**PRELIMINARY DRAINAGE REPORT
FOR
JUDGE ORR ROAD COMMERCIAL PARK
EL PASO COUNTY, COLORADO**

May 2025

Job No. 25315.00

PROPOSED DRAINAGE MAP

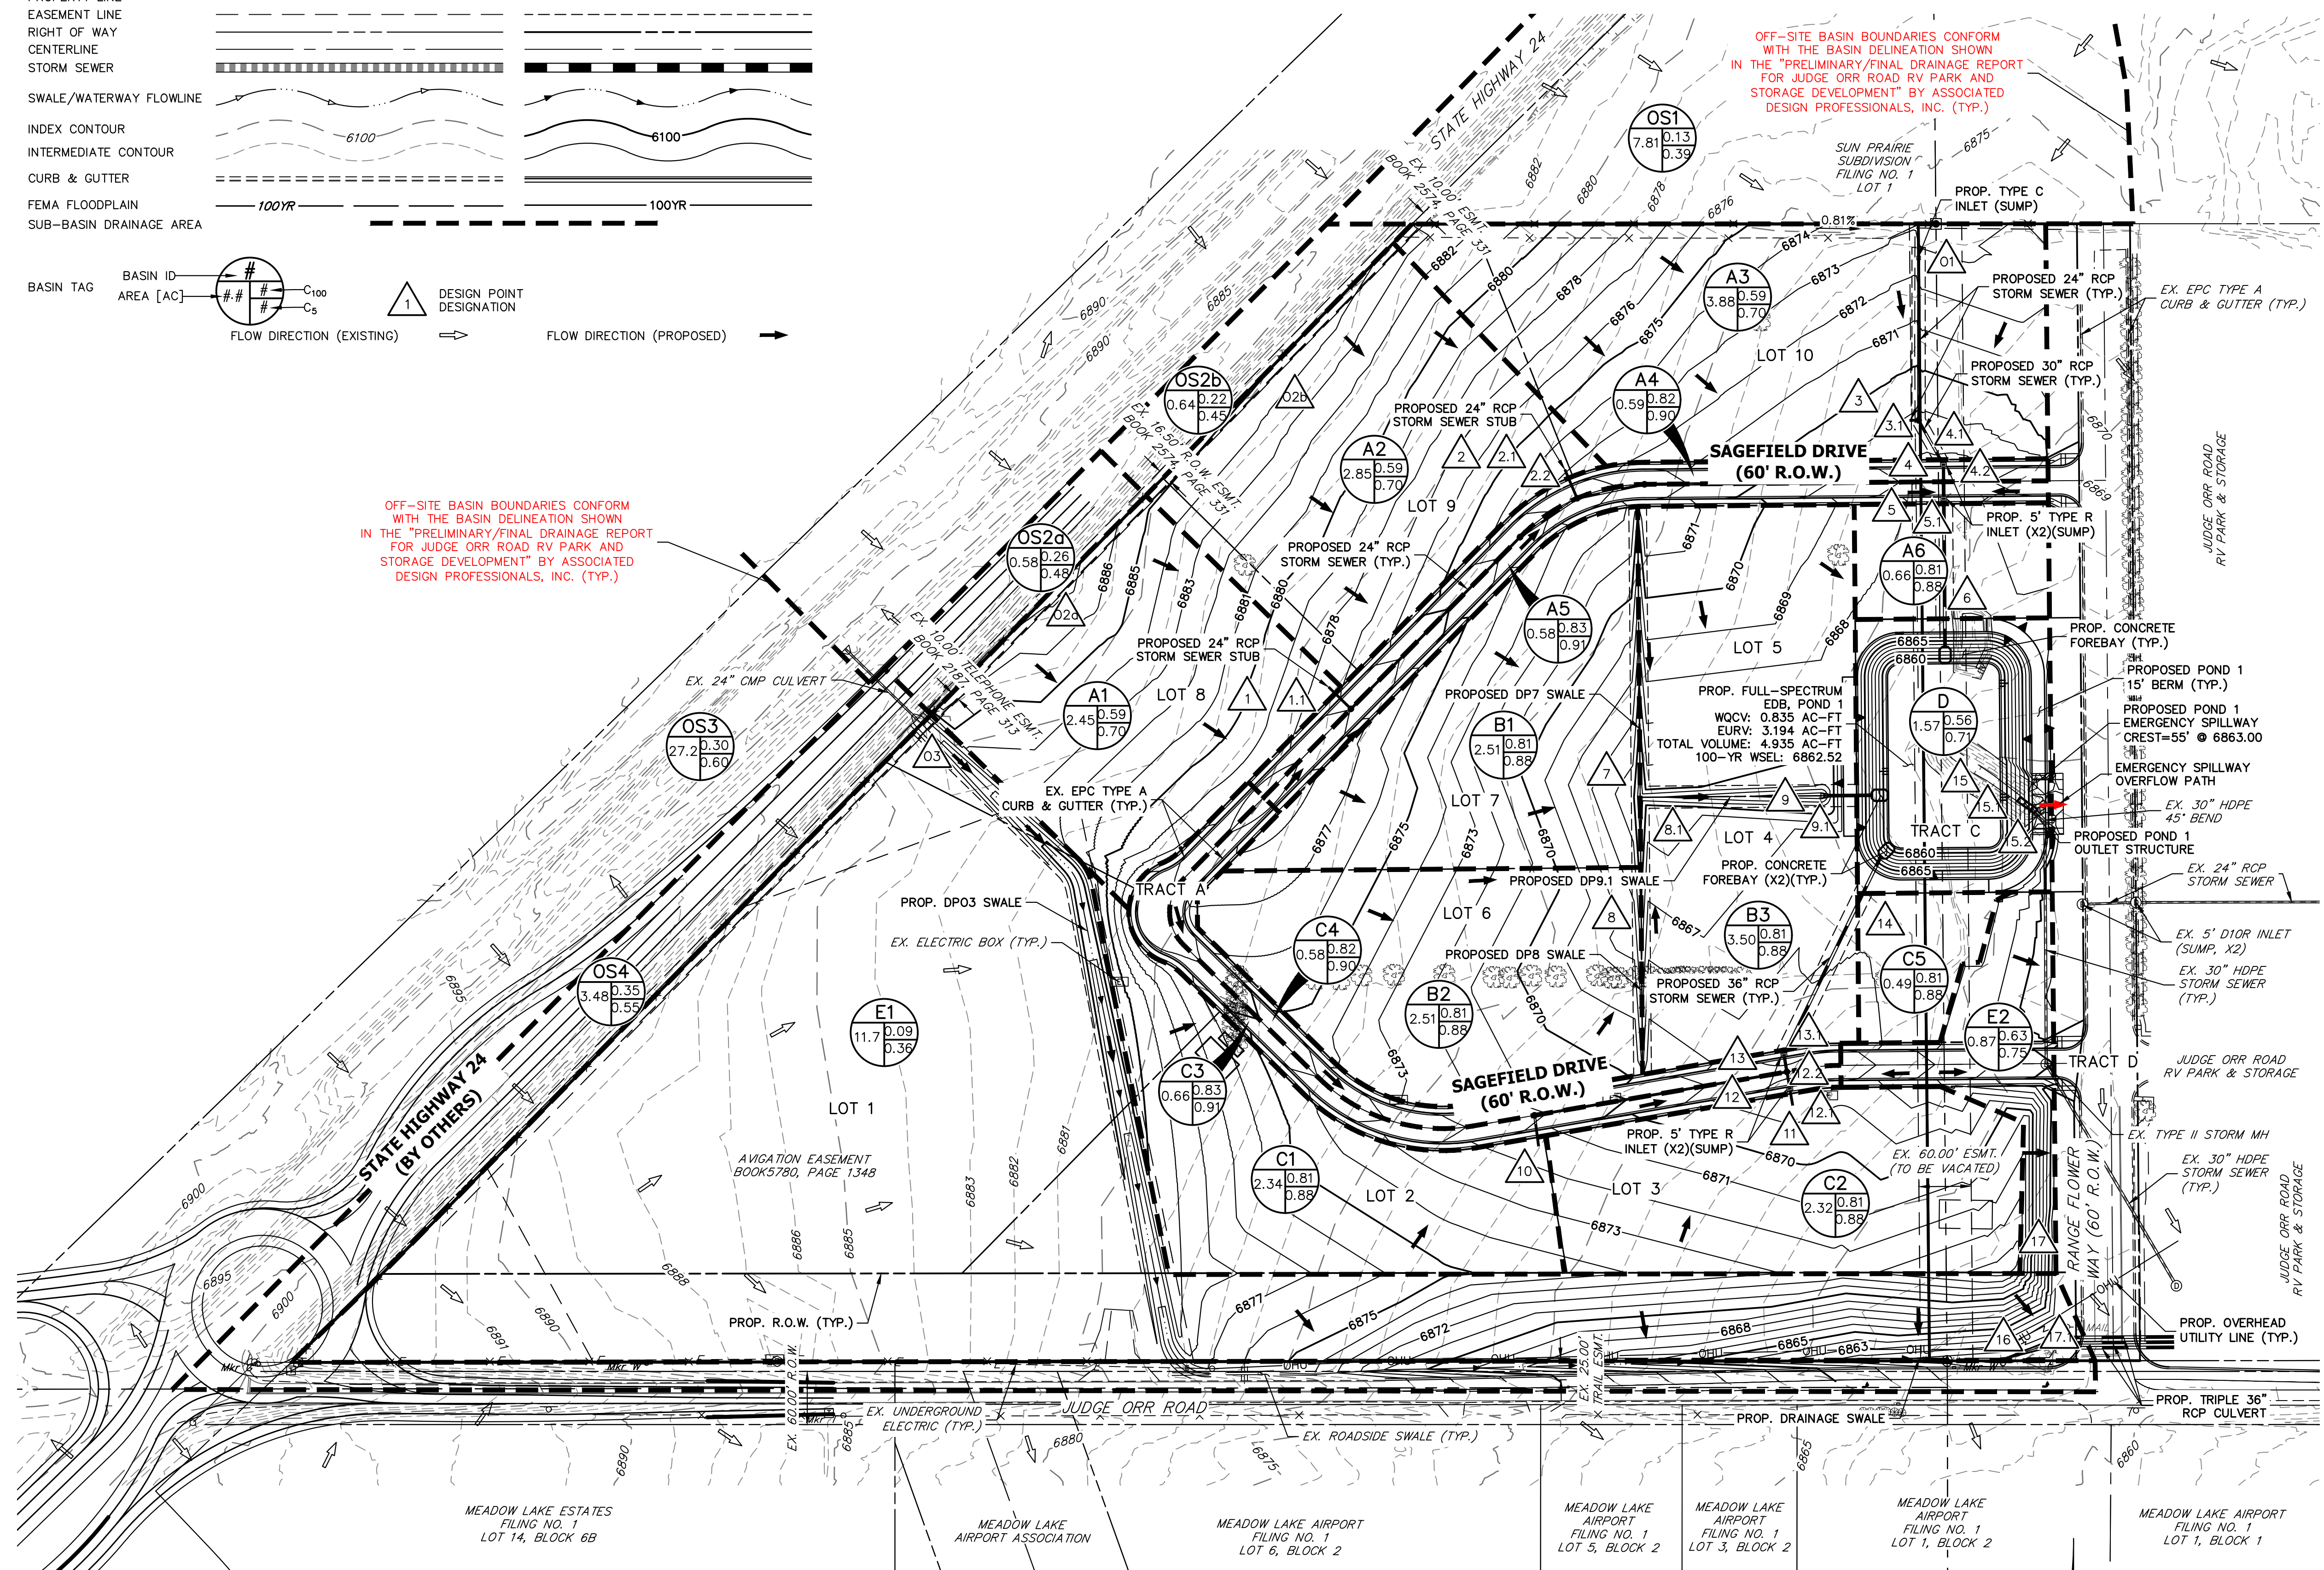
It appears Sagefield is a private road, therefore it would be a 60' access easement or tract and not ROW.

Will it be a tract if it will not be built on?

Will require a PCM Identifier (i.e. Pond 1, Pond A, etc.) for project pond will be constructed under.

Use same Pond name
